MAYBERRY COMMUNITIES

SECTION 14 & 15, IN TOWNSHIP 14 SOUTH, RANGE 63 WEST OF THE 6TH PRINCIPAL MERIDIAN,
EL PASO COUNTY, COLORADO.

SKETCH PLAN

COVER SHEET

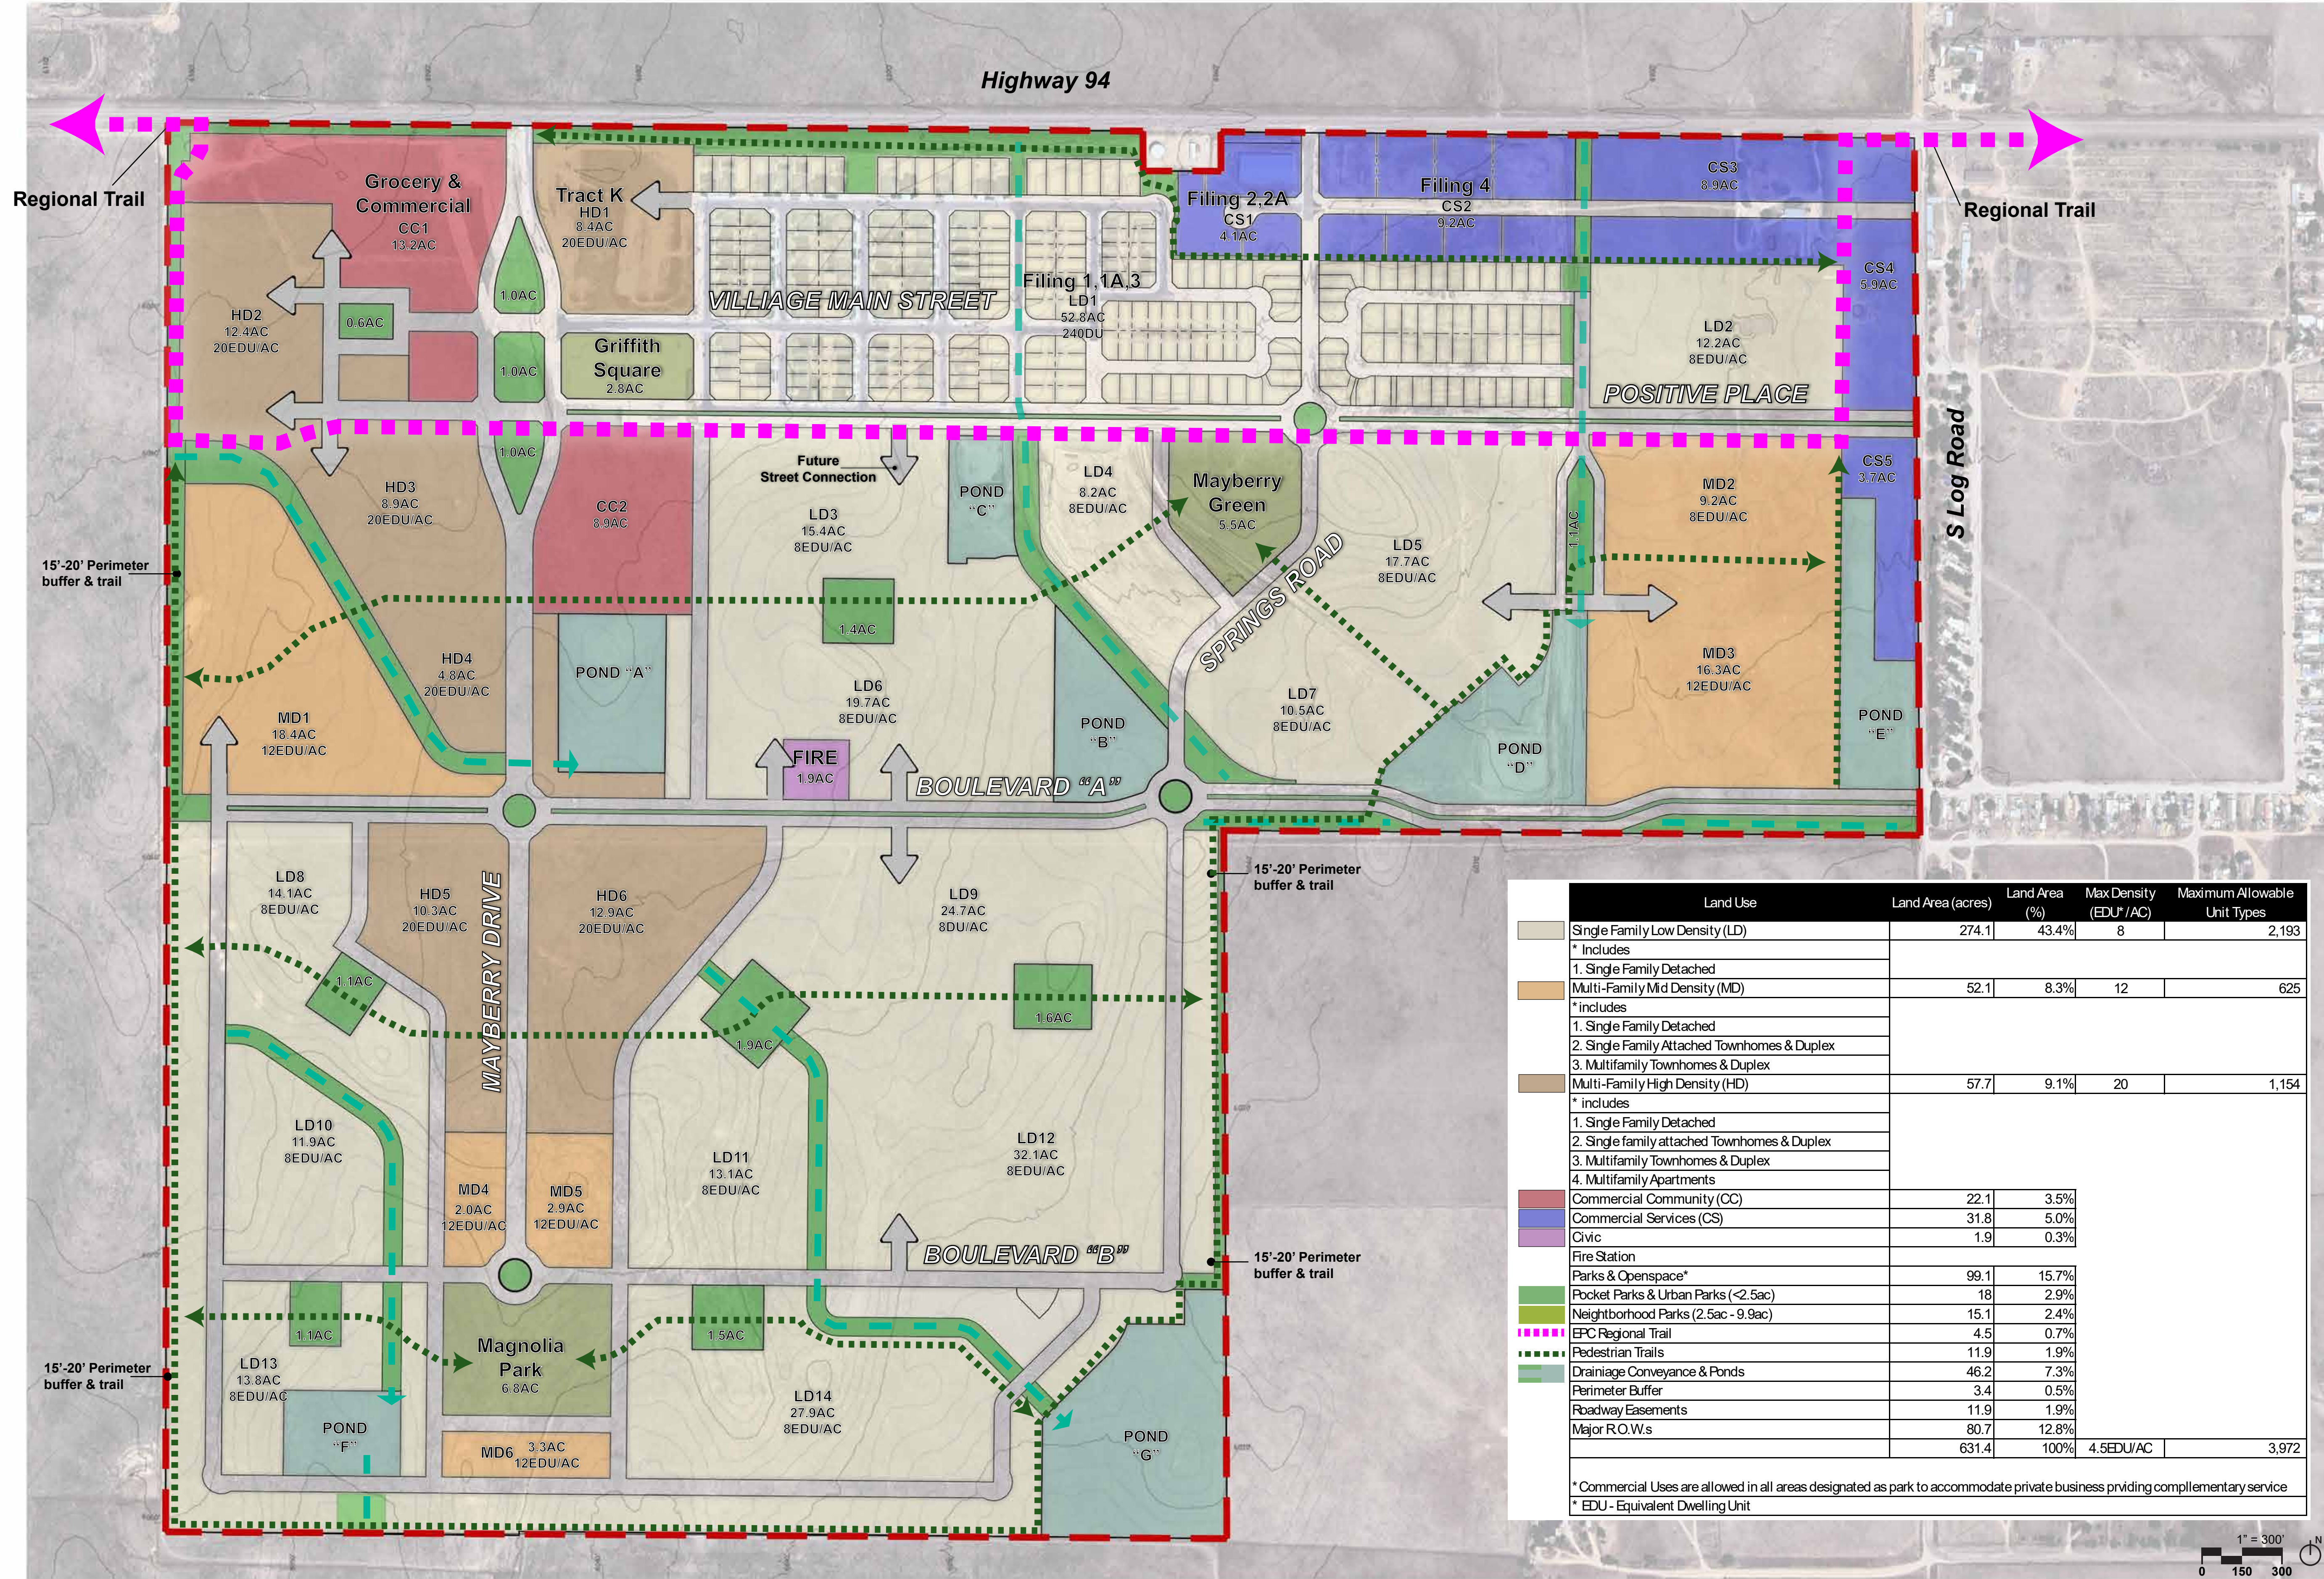
The title block has been removed. Please add it back in.

Per CGS comments, include the following recommendations to be performed placed on the plan in the note:
• "preparation of design-level geotechnical investigations for the proposed buildings to develop specific foundation recommendations for the design and construction of foundations and floor systems."
• "Foundation drains should be constructed around the lowest excavation levels of basement and/or crawlspace areas and should discharge to a positive gravity outlet or to a sump where water can be removed by pumping."

Include the acreage in the legal description.

This should be elaborated further. I understand it's in the table on the next sheet. Per our Code, townhomes are basically single-family attached, and multifamily is intended for units that don't all share first floor access and have shared ceiling/floor space with other units. Townhomes and duplex are considered single-family attached. Based on discussions with the applicant, I believe the intent is to have a grand total number of units and a flexible maximum of each unit type. You should explain this concept in the note.

I think this note is confusing. You can state that landscape and open space will be maintained by a district (explain which district), but the second part of the note is confusing. Is the intent that all multifamily components will take care of their own maintenance? This is also something that can be more specifically identified at the PUD / Preliminary Plan stage.

Not sure what the intent is here. I recommend you delete this, as it can be seen as a circumvention of commercial zoning.

This appears to be incomplete

Change this sentence to say "a deviation request and/or PUD Modification will be required to be reviewed and approved prior to acceptance of any design ..."

I recommend updating this note to allow discretion as to whether a change constitutes an amendment to the sketch plan.

Preliminary plans will require site-specific geotechnical evaluations, per Sec. 8.4.9 of the LDC. During preliminary plan stages for future phases, site-specific data should be collected to evaluate the potential for shallow groundwater. If significant grading or below-grade levels are planned, the potential for shallow groundwater will require further evaluation. Investigations for natural fluctuations in shallow groundwater should include monitoring programs that can be used during preliminary and final plans using site-specific groundwater elevation data.

SKETCH PLAN

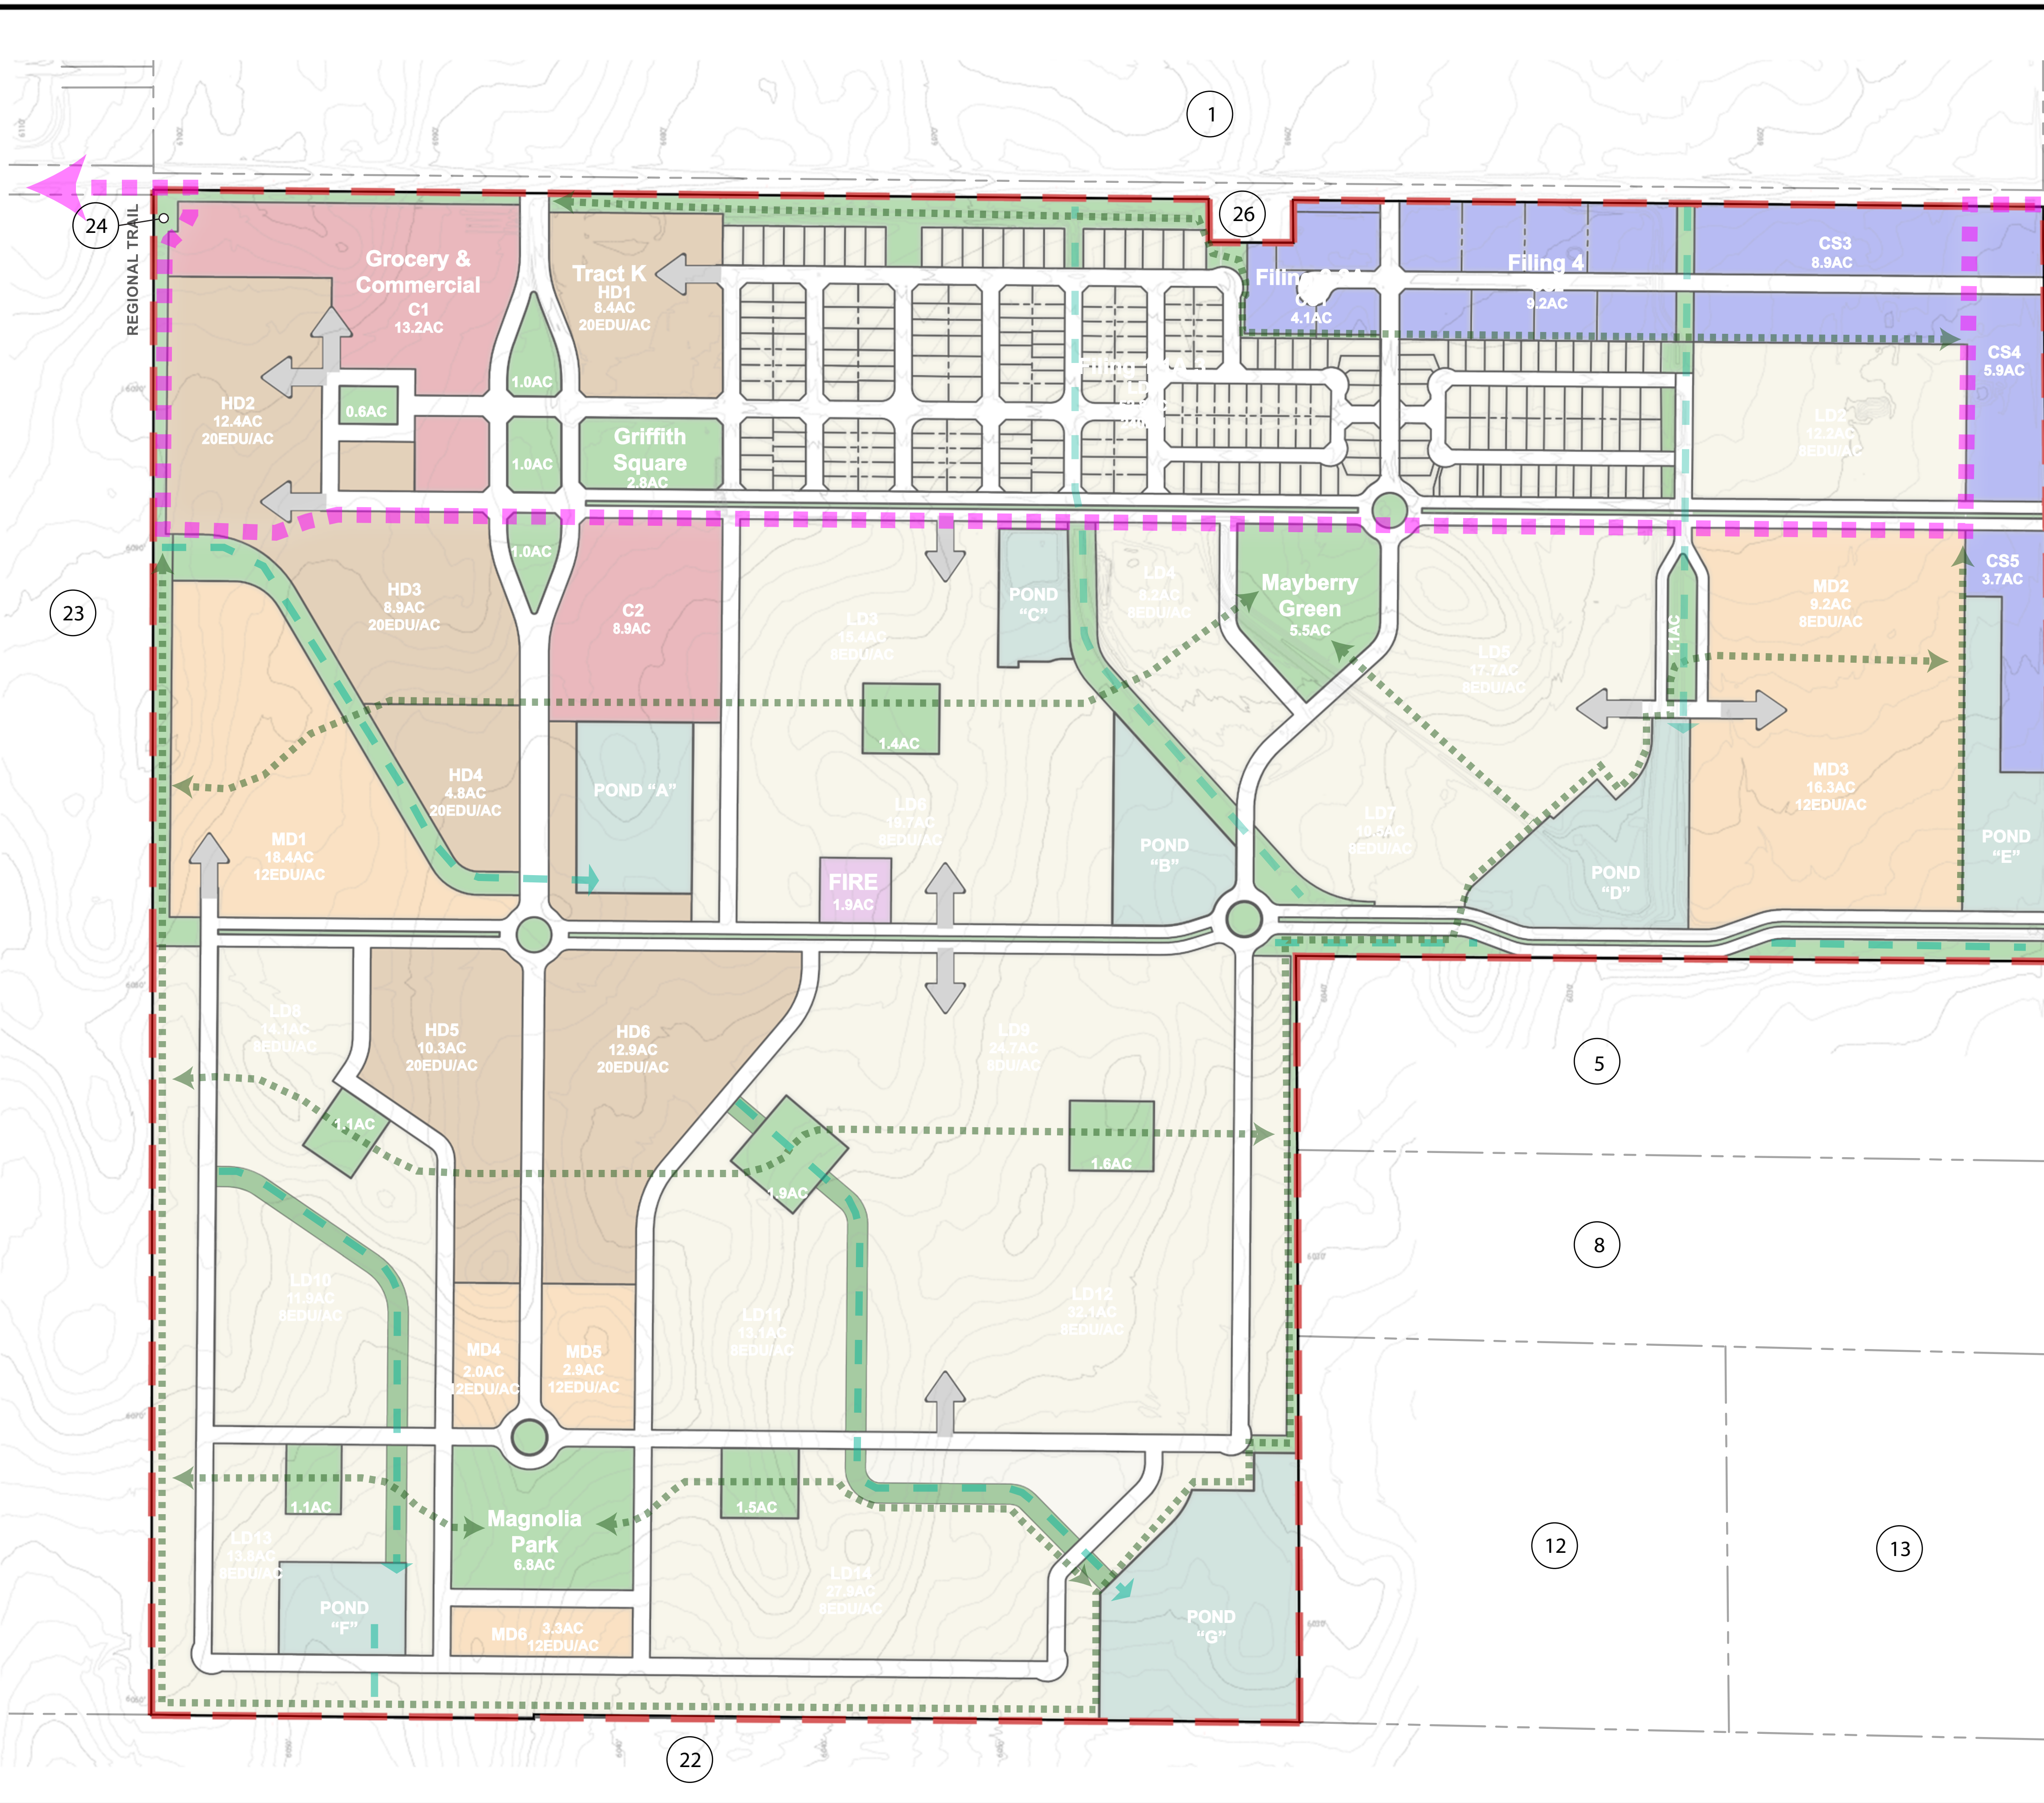
If the grand total is 2,800, then these unit estimates are subject to change based on the total of 2,800.

Note max should be 2,800 units.
